Please upload onto Ocella the email below which is the consultation response from the **ADC Conservation Officer** to planning application **A/24/21/PL** regarding Land South of Water Lane, Angmering.

A/24/21/PL

Land South of Water Lane Angmering

Erection of a temporary sales cabin with 4 parking spaces and associated landscaping. CIL Zone 1 - This application is zero rated as temporary building

Project  
**Land at Water Lane,  
Angmering, West Sussex.**  
Drawing Title  
**Sales Area Layout**

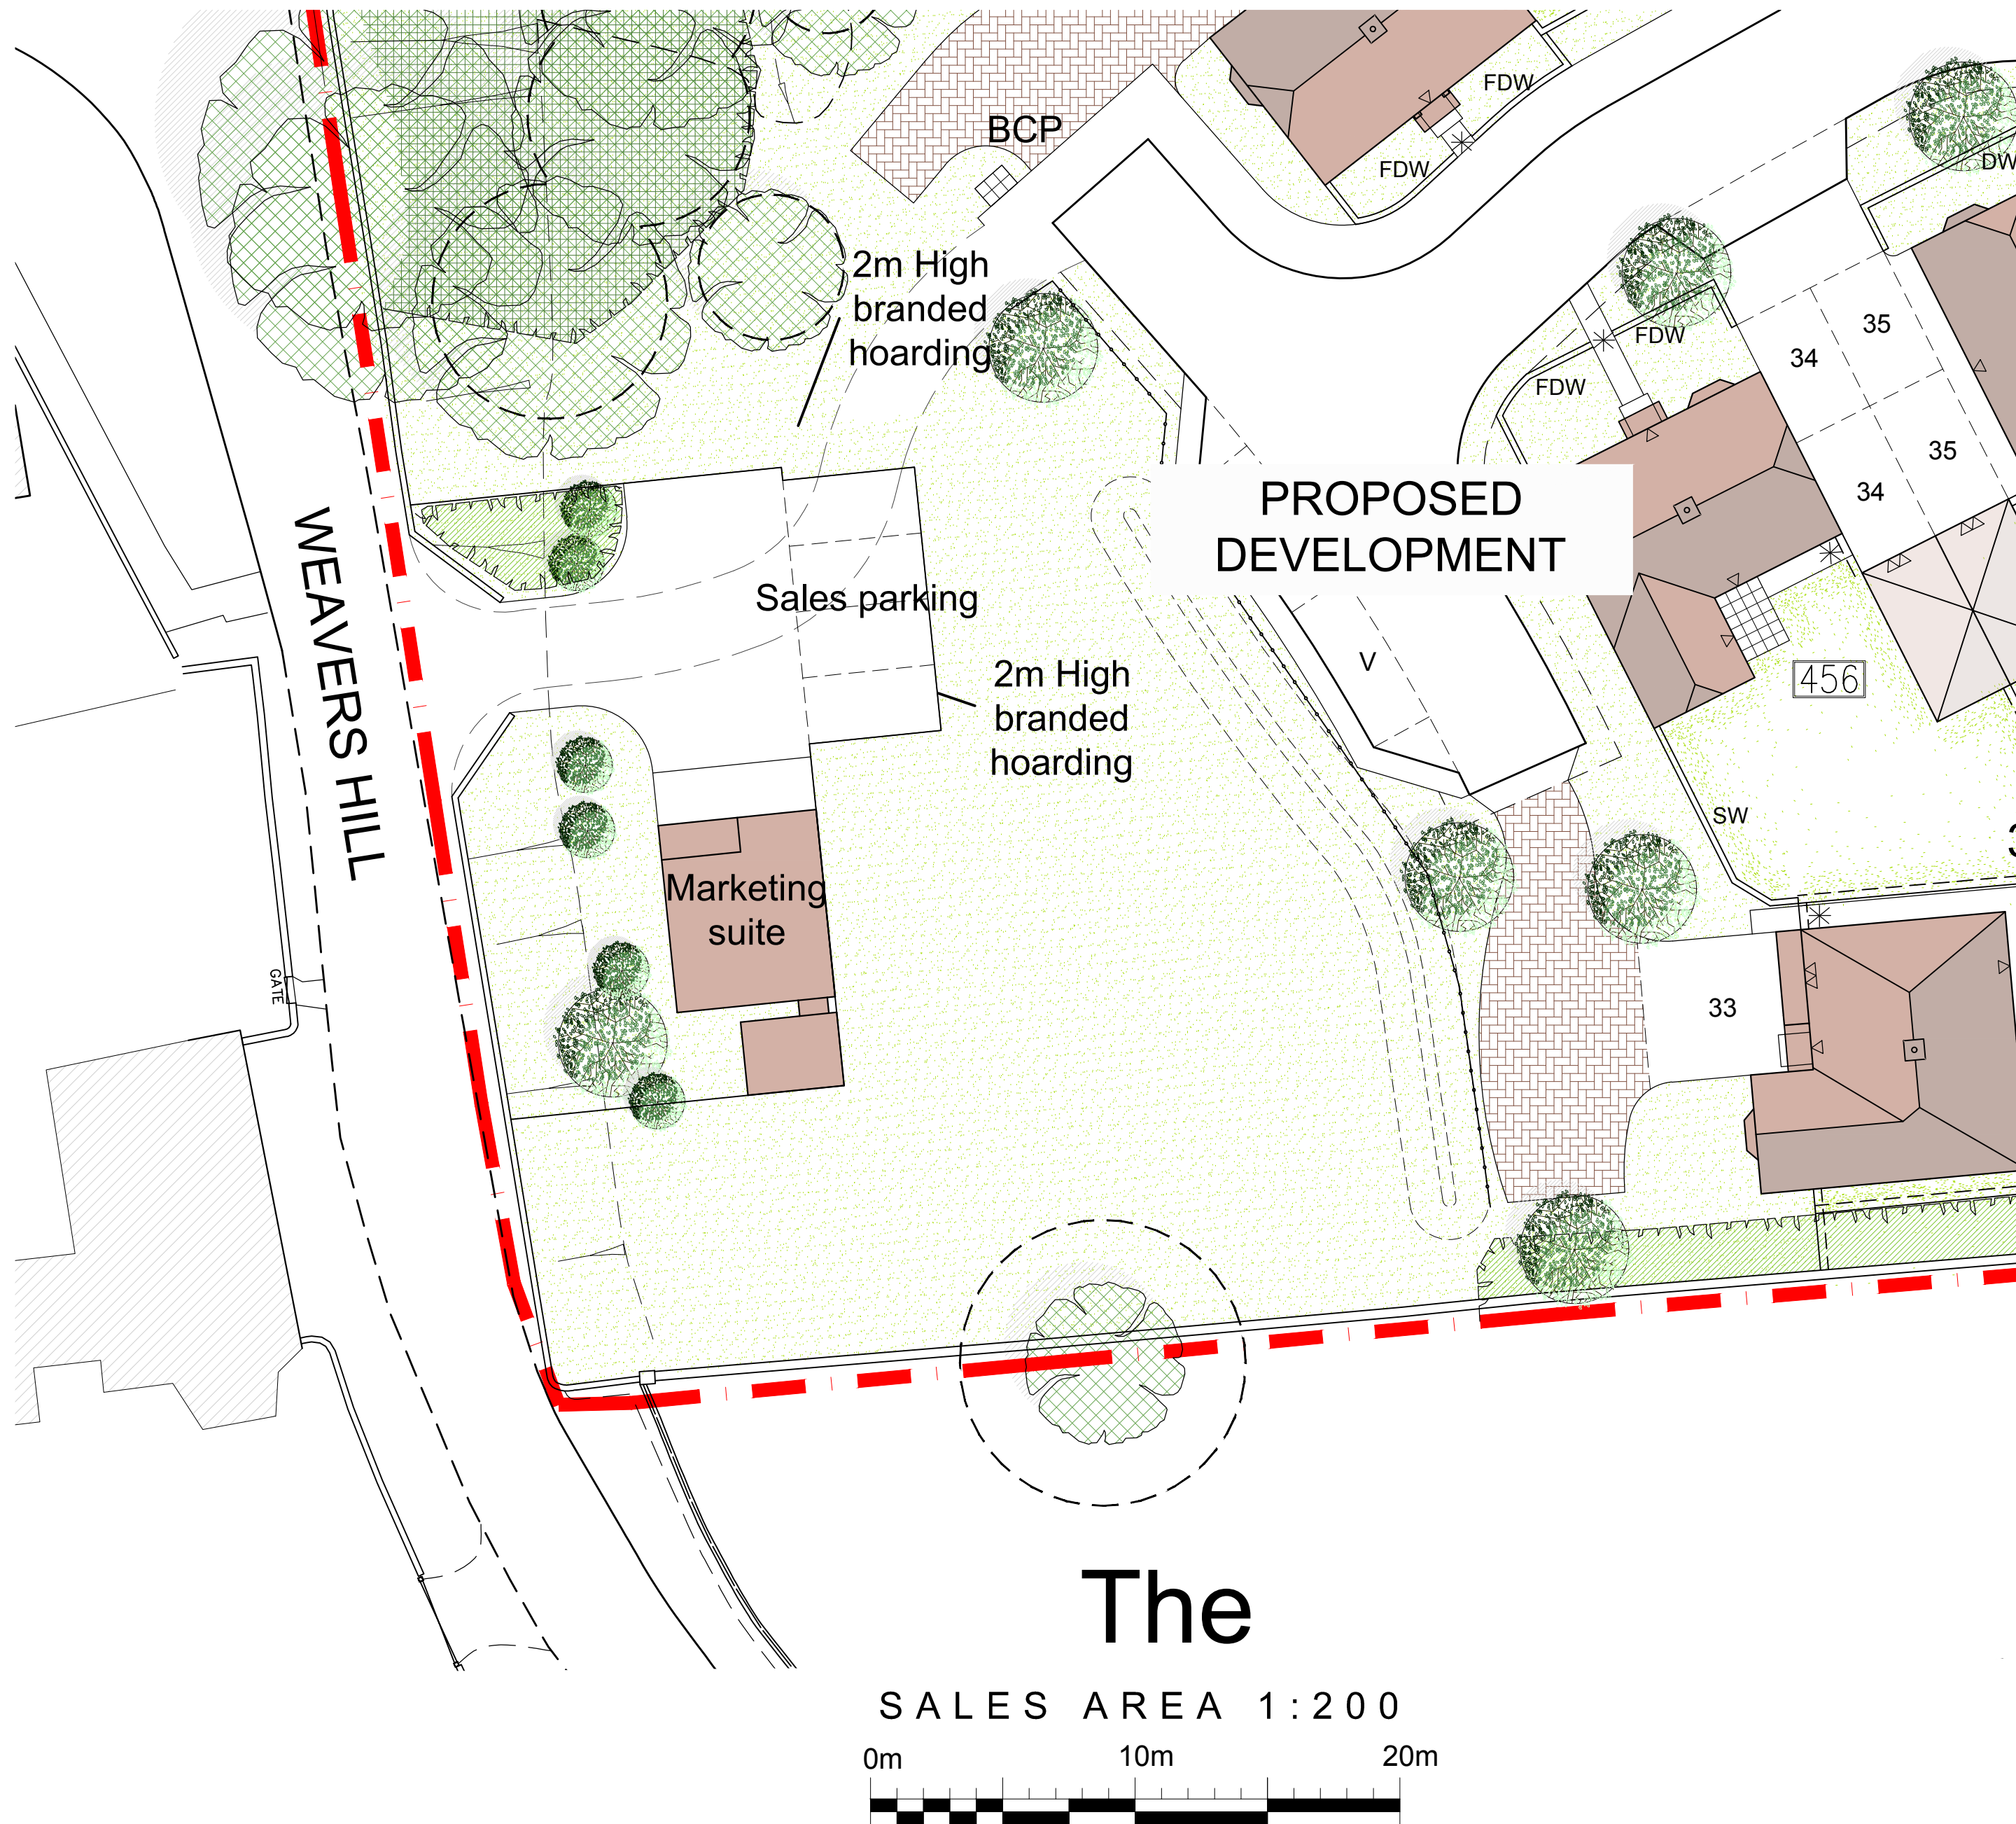
The proposed site plan indicates that the location of the temporary cabin is in an area to be landscaped and retained as open space as part of the approved development. The cabin is a fairly simple structure with glazing on the principal elevation and decorative panels on the remaining. These panels include the companies standard branding. A scheme of landscaping has also been provided, which could attempt to soften its impact.

I also note that the intention is for the vehicular access to be from Weavers Hill. Weavers Hill is narrow, with the flint walling fronting almost directly onto it. It is noted that this will utilise an opening which was approved as part of the reserved matters planning application and that this application does not involve the removal of any further sections of the flint wall that has not already been consented.
